App No: AL/20/18/OUT

Address: Land at Bridge Cottage & The Old Cottage Lidsey Road Lidsey PO22 9PH

Proposal: Outline application with all matters reserved for the demolition of 2 No. dwellings & associated outbuildings & the erection of up to 27 No. dwellings, of which 30% will be affordable, with associated open space & access. This application is a Departure from the Development Plan.

Liz Rogers
Environment Officer
Environment
Chichester District Council

Drawing Title: Site Habitat Plan

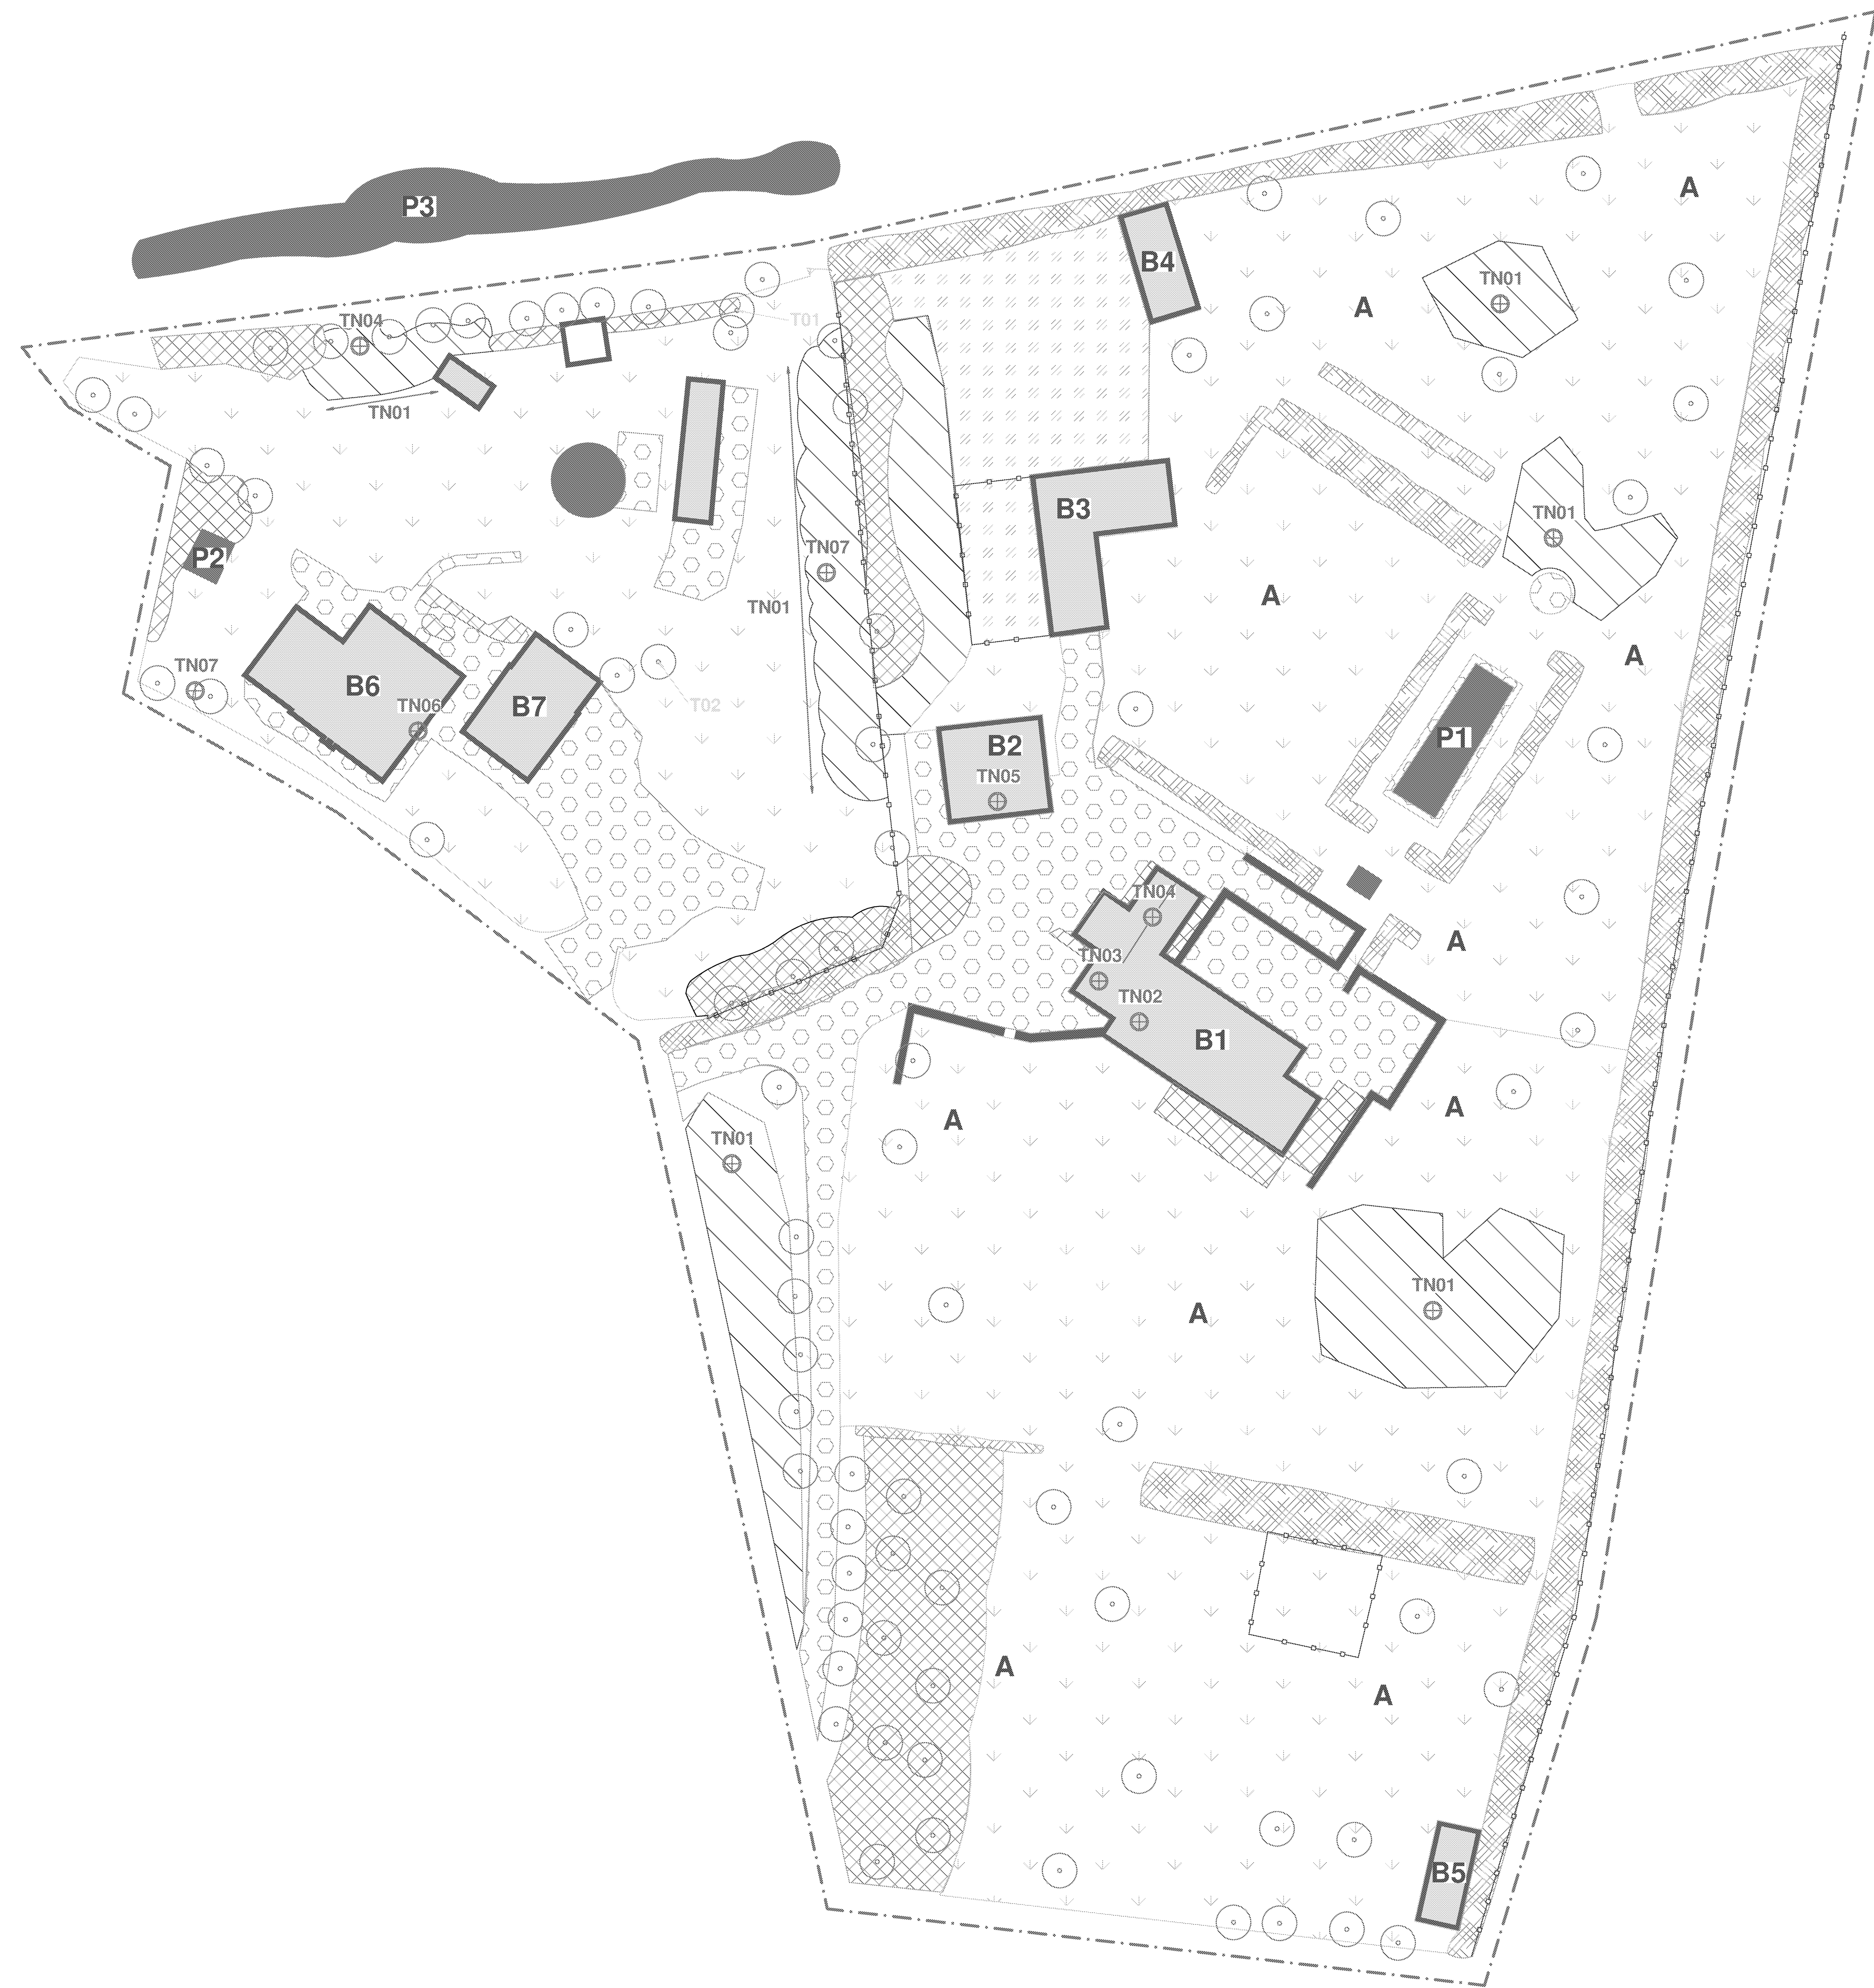
Trees T01 and T02 will need to be retained due to the bat roosting potential they hold. Please can we have confirmation that these trees are remaining onsite. If they do need to be removed further bat surveys will be required on them.
